# TRAFFIC IMPACT STUDY

**Schmidt Rezone  
El Paso County, Colorado**

August 2024

**SM ROCHA, LLC**  
TRAFFIC AND TRANSPORTATION CONSULTANTS

Figure 1
SITE LOCATION
 Overall Acreage (Developable Acreage)

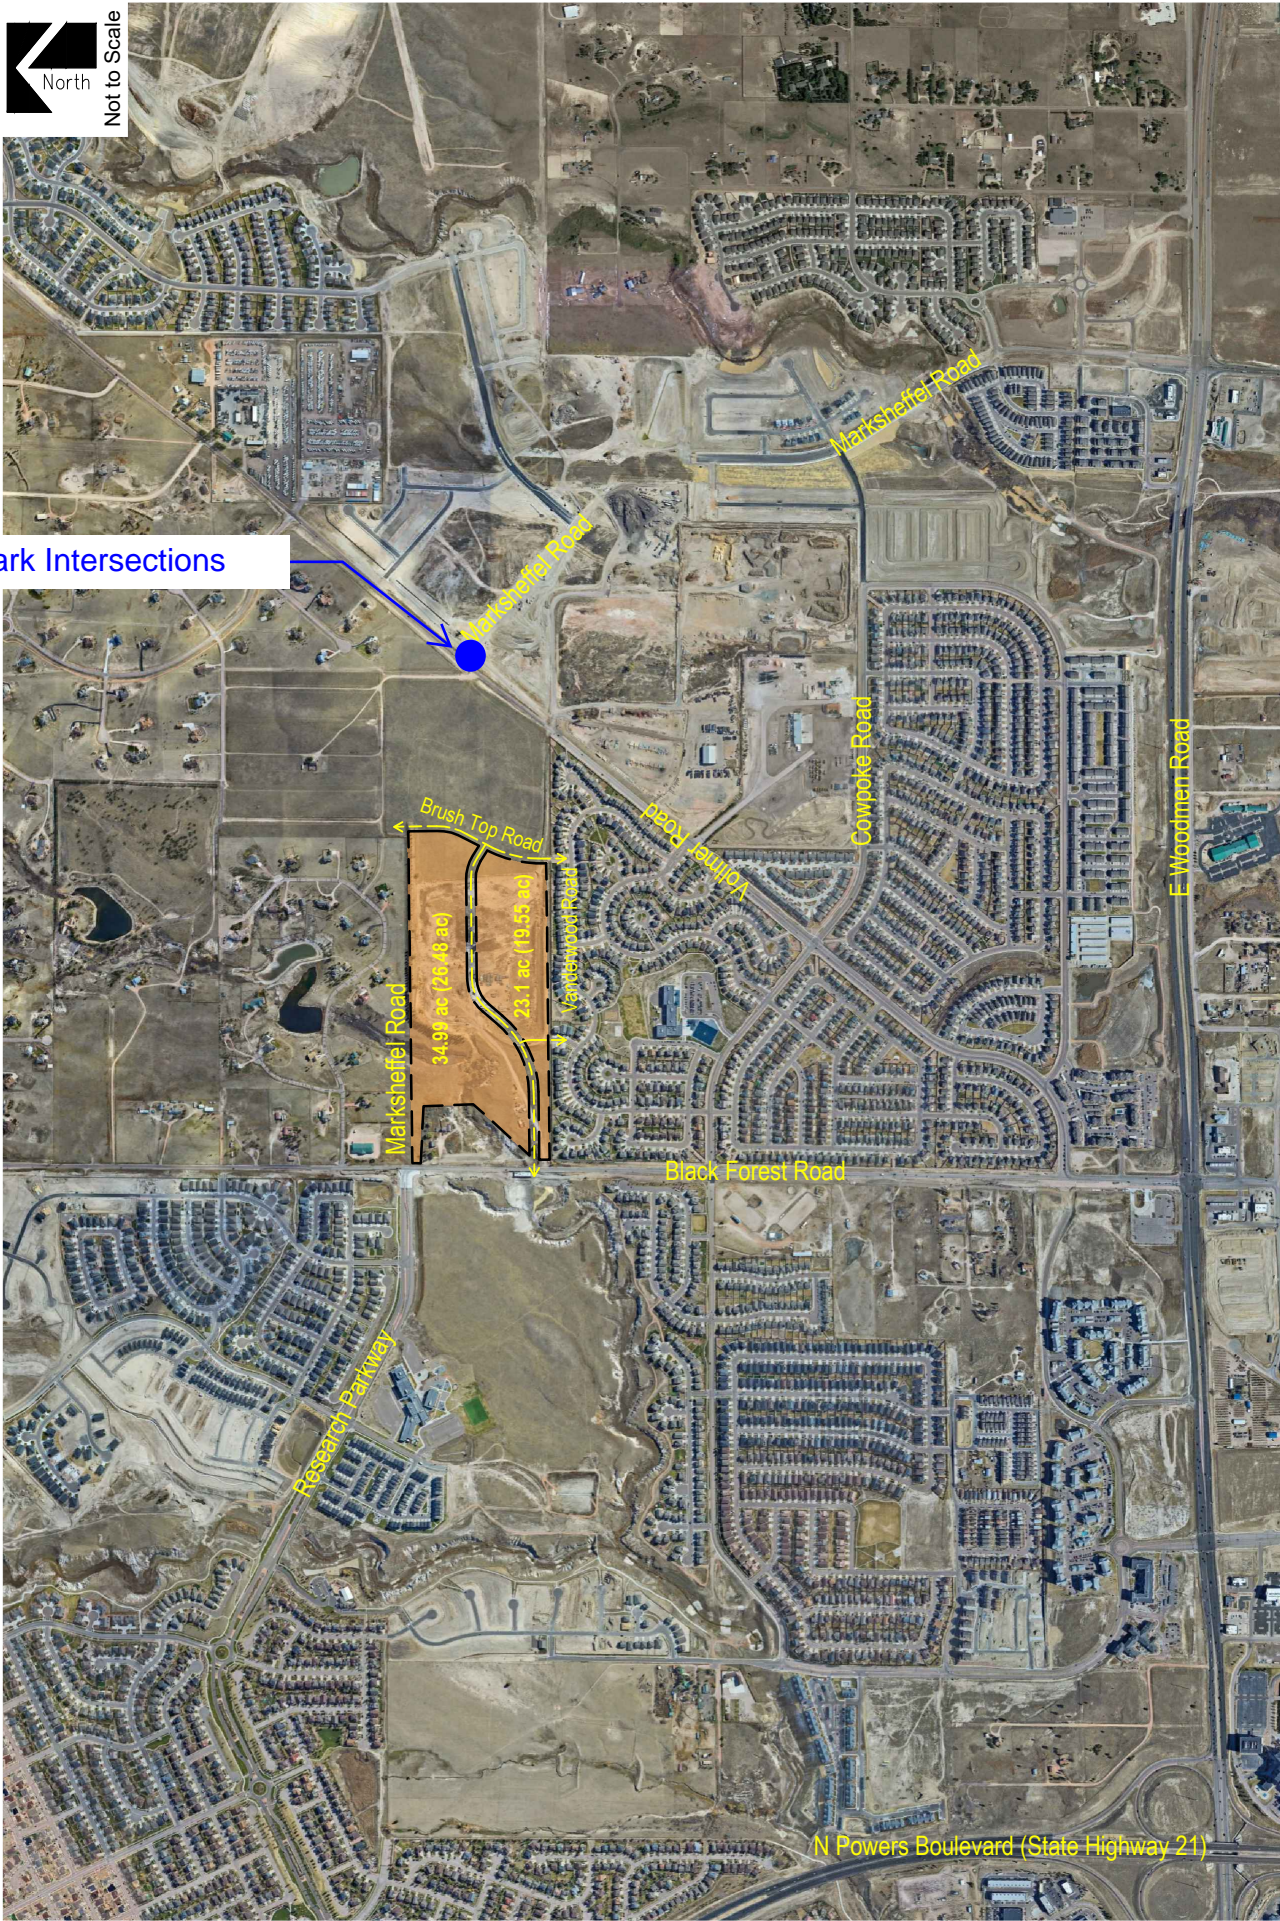
Symbolize study intersections on map please

Mark Intersections  
Symbols added.

Please update here and footnote - 2024

MTCP updated.
